B L E G G E N R E M O D E L

APPROVED
Limited building only review
Permit holder responsible for full compliance with the code

ATTIC REMODEL
1/4" = 1'-0" CLG HGT. = EXIST.

ATTIC REMODEL
1/4" = 1'-0" CLG HGT. = EXIST.

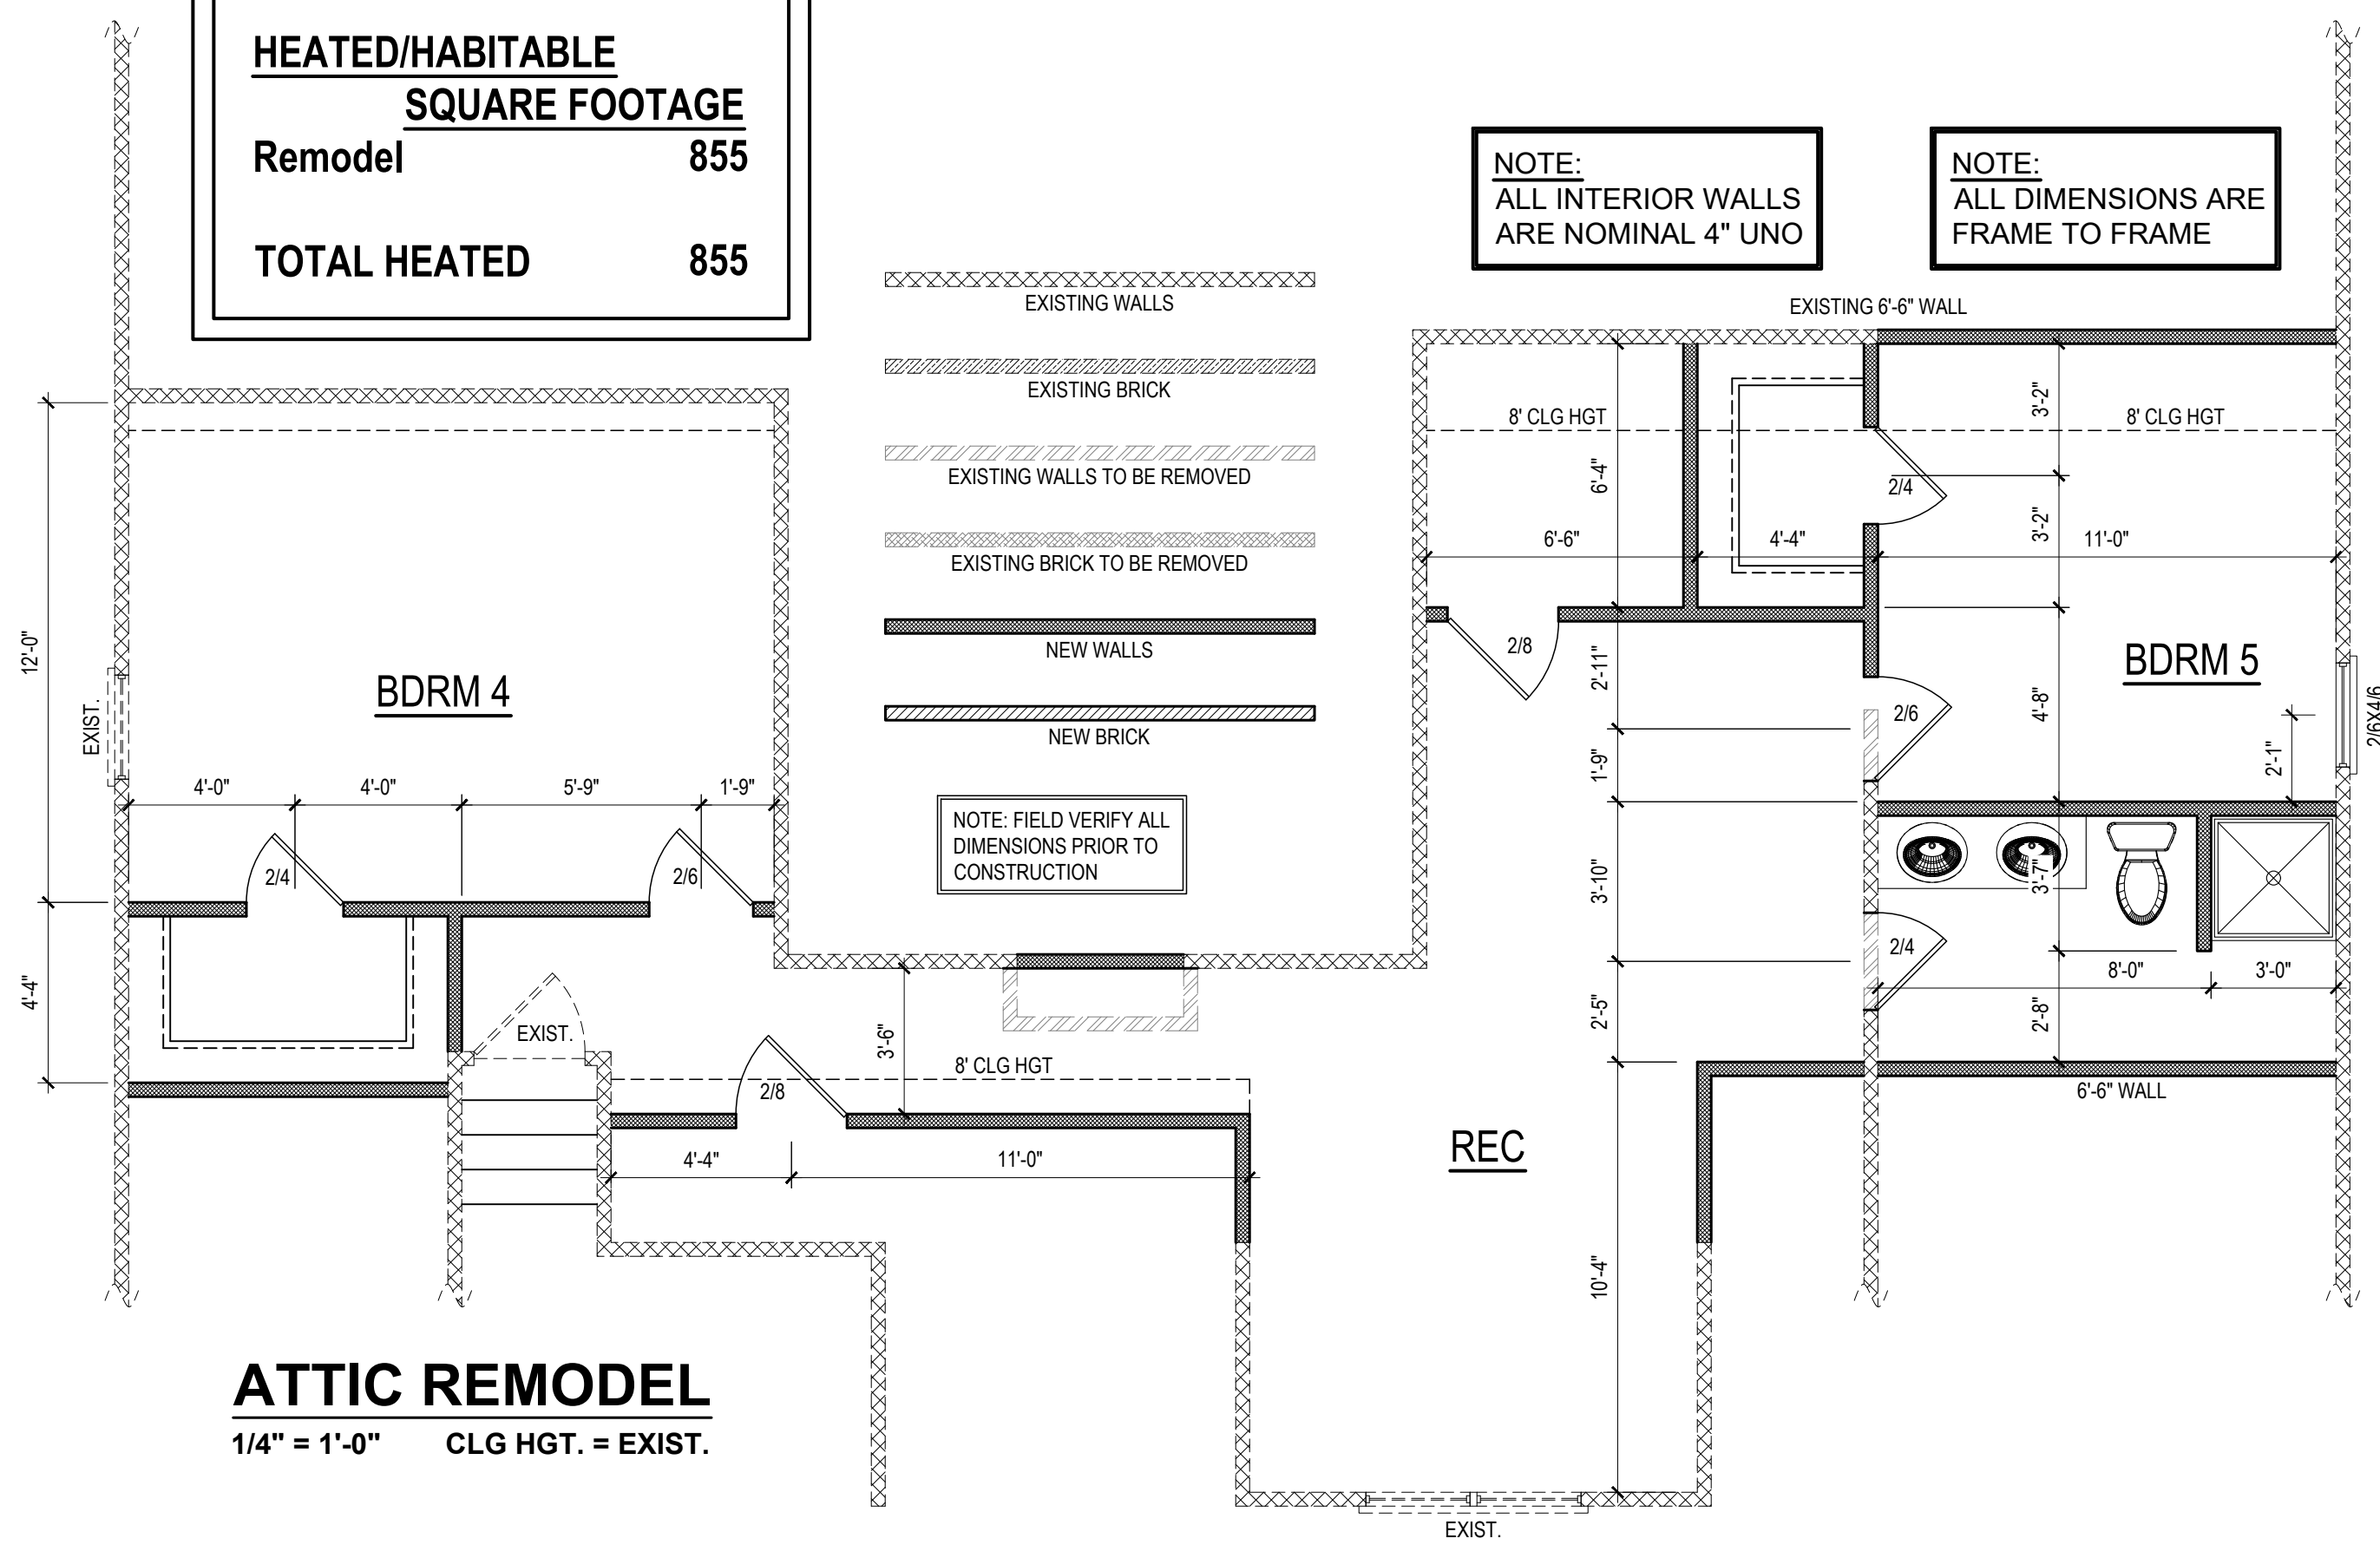
This window must meet egress requirements
